Your Ref : 2018/92850

New modification s to Application to demolish bungalow at 77 Latham Lane and build detached dwelling

Rev: A	GARAGE BLOCK DELETED	NOV 18
DRAWN :	GAF	DATE : AUGUST 18
CHECKED :		SCALE : 1:100 @ A3
TITLE :		
77 LATHAM LANE, GOMERSAL, AMENDED HOUSE TYPE SIDE ELEVATIONS		
DRAWING No:	7002-003-01	REV A

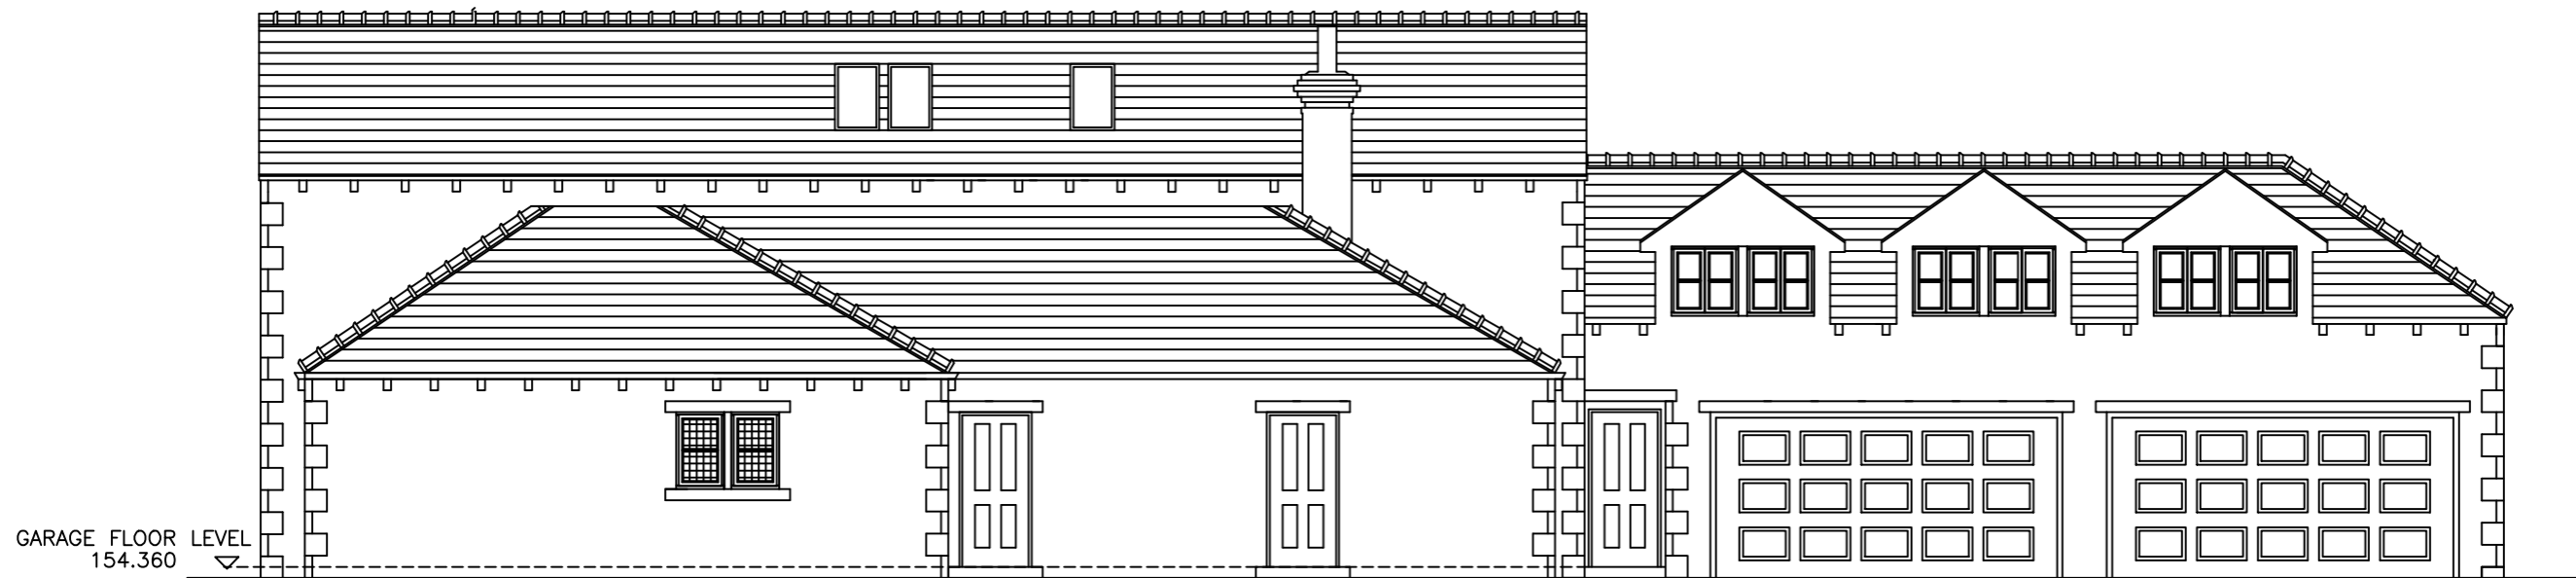
c) The land slopes towards our property and in addition there is a 600 millimetre difference in land level between 77 and 75 starting from our building along the rear length of our land It is an immediate drop requiring a retaining wall (it is not visible from the road and we are willing to give access for this to be confirmed).

This difference will mean that the ridge height will be considerably higher on our side
